DECISION DELEGATED TO HEAD OF PLANNING

Application No: H16-0342-24 **Applicant:** Belcast Holdings Ltd

Proposal: Details of external doors & door frames, window frames & roof lights
(Conditions 6, 7 & 8 of H16-0887-23)

Location: 2 New Road And 1-3 Chapel Lane Spalding Lincolnshire

WINDOW 9,10,11

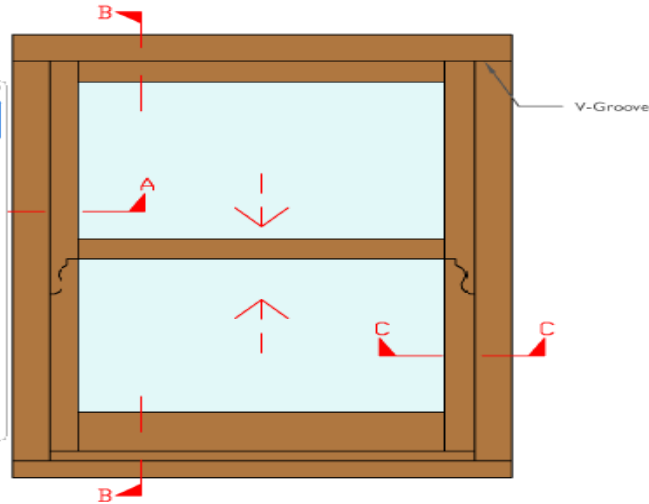
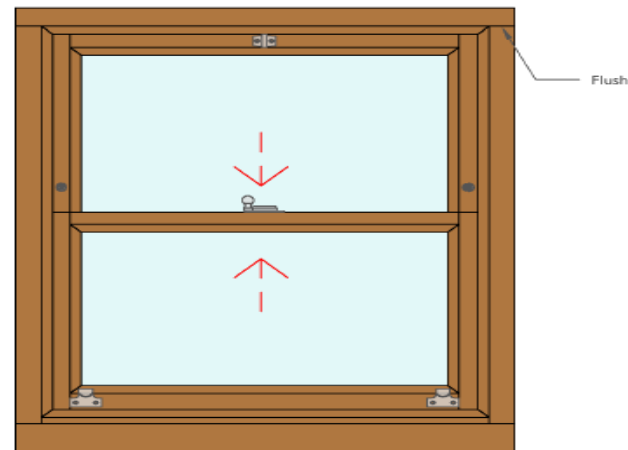
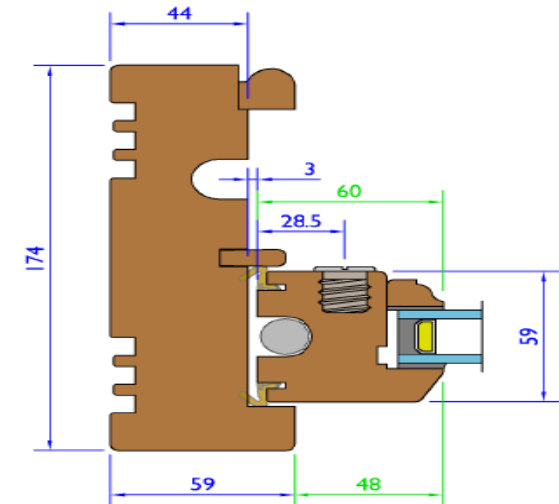
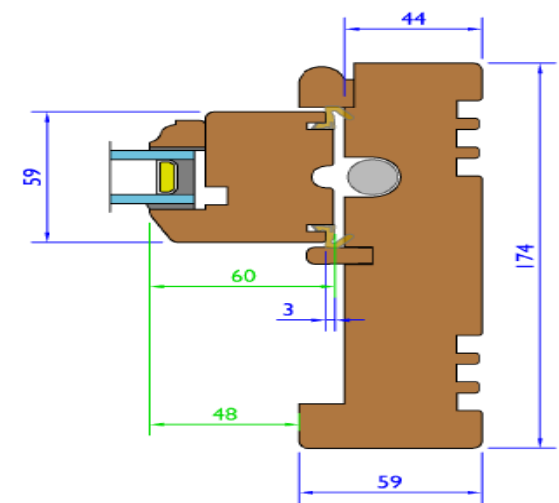
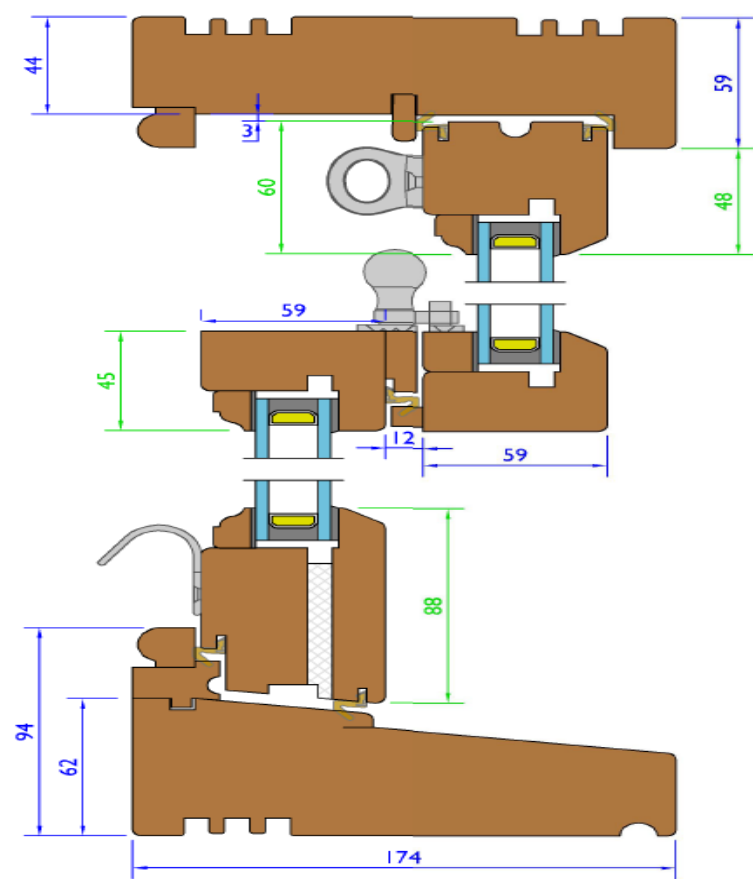
The applicant has supplied details of the proposed windows to be utilised throughout the property. A mixture of UPVC and timber are proposed. The applicant proposes that PVC be used to the rear of 2 New Road as well as 1 and 2 chapel lane, which are not listed, unlike number 3. All windows to street frontage elevations are proposed to be Timber sliding sash windows, and all windows throughout the listed 3 Chapel lane are similarly proposed to be timber.

The proposed details of the timber windows are considered to be acceptable, and therefore, the details provided to discharge this condition are deemed to be permissible.

Rear Elevation - Bentleys

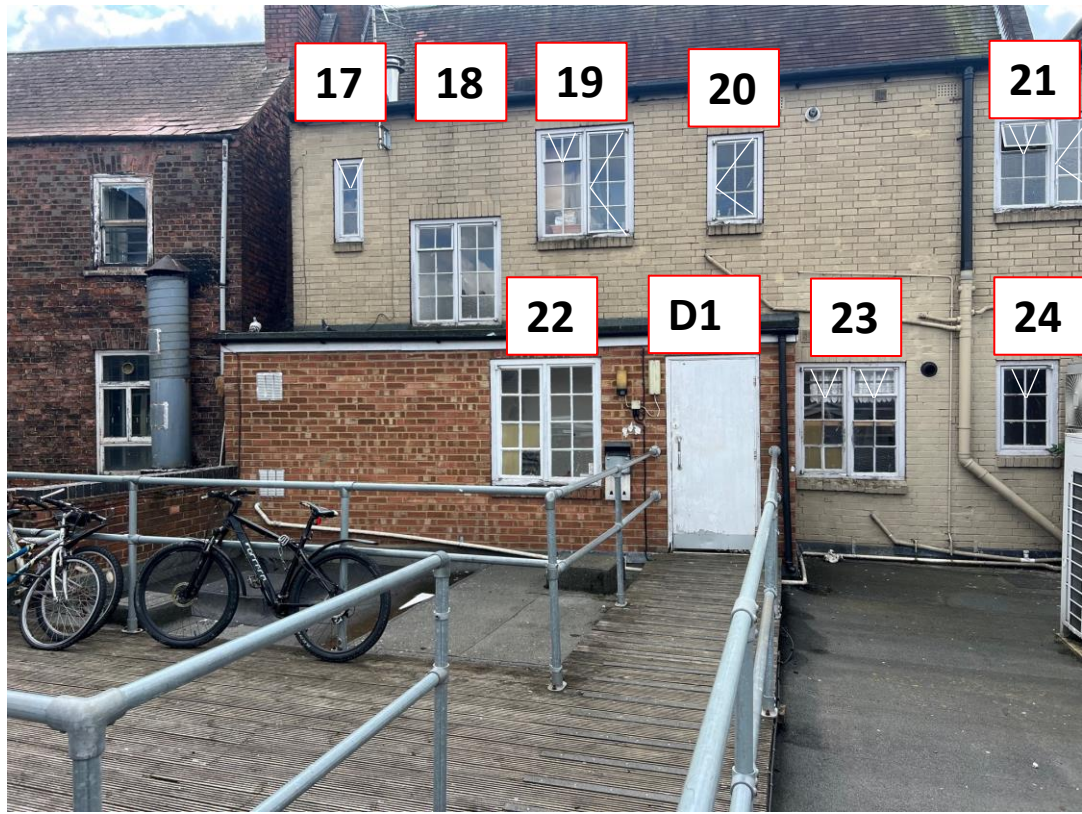
The applicant has supplied details of the replacement door to be utilised on the rear of 2 new road, which is a standard PVC non-glazed door - typically such doors would not be permissible in a conservation area setting due to the non traditional material of construction and plain design. However, as 2 new road is not listed and the door to be utilised in placed on a rear elevation that is not readily visible from any public realm views, it is considered that it would not be reasonable in this circumstance to require the applicant to specify timber, traditional doors, in a position which has no bearing upon the wider appreciation of the Conservation Area. Therefore, the details provided are acceptable.

Rear Elevation - Restaurant

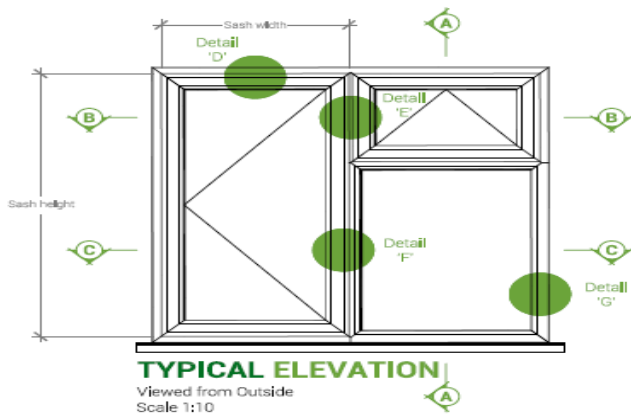
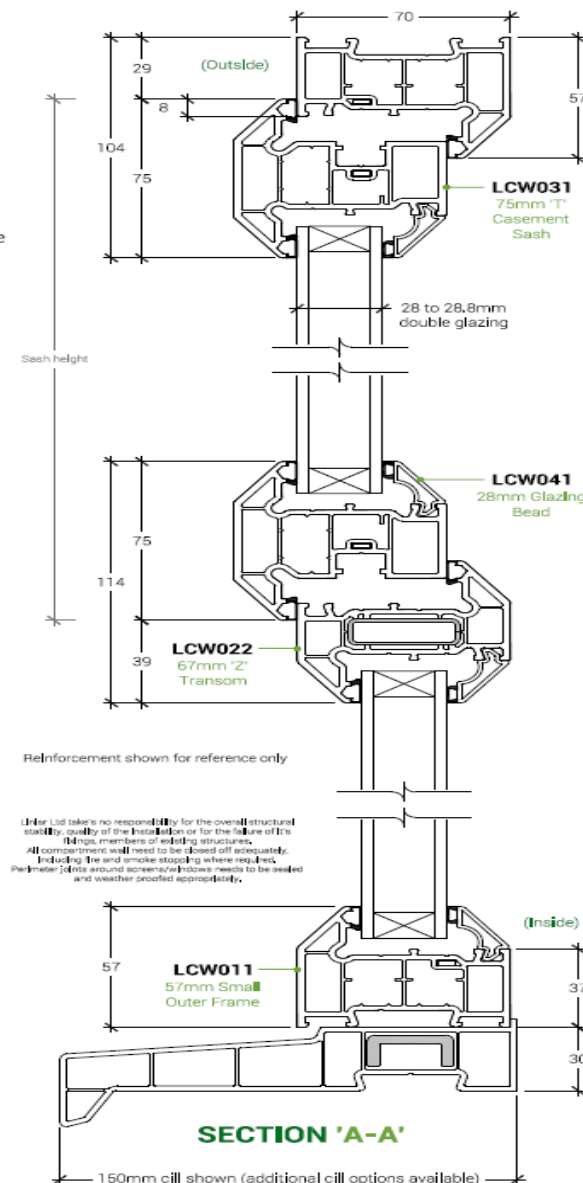
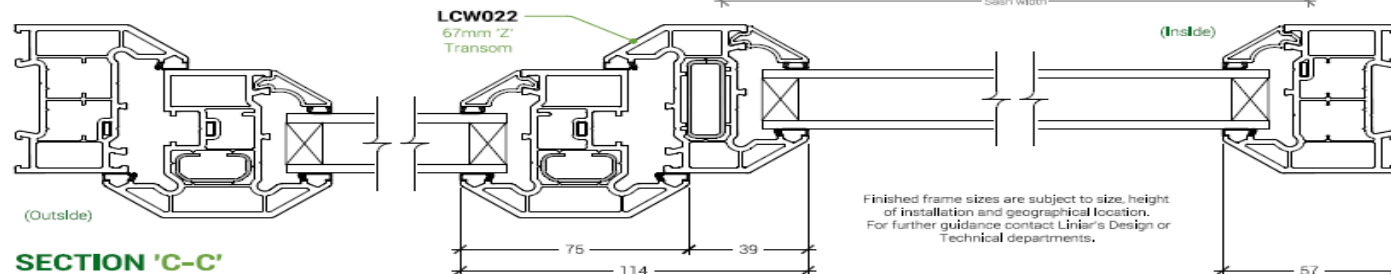
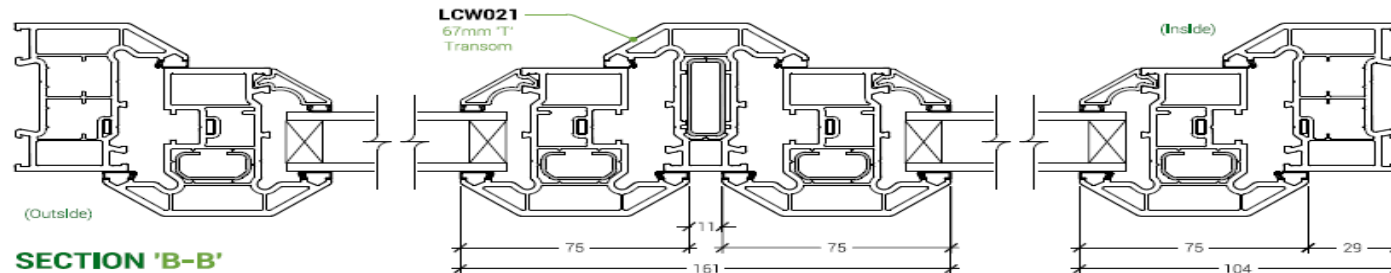
Typically UPVC windows would not be permissible in a conservation area setting due to the non traditional material of construction and divergent design. However, as 2 new road or 1&2 chapel lane are not listed and the windows to be utilised are to be placed on a rear elevation that is not readily visible from any public realm views, it is considered that it would not be reasonable in this circumstance to require the applicant to specify timber, traditional windows, in a position which has no bearing upon the wider appreciation of the Conservation Area.
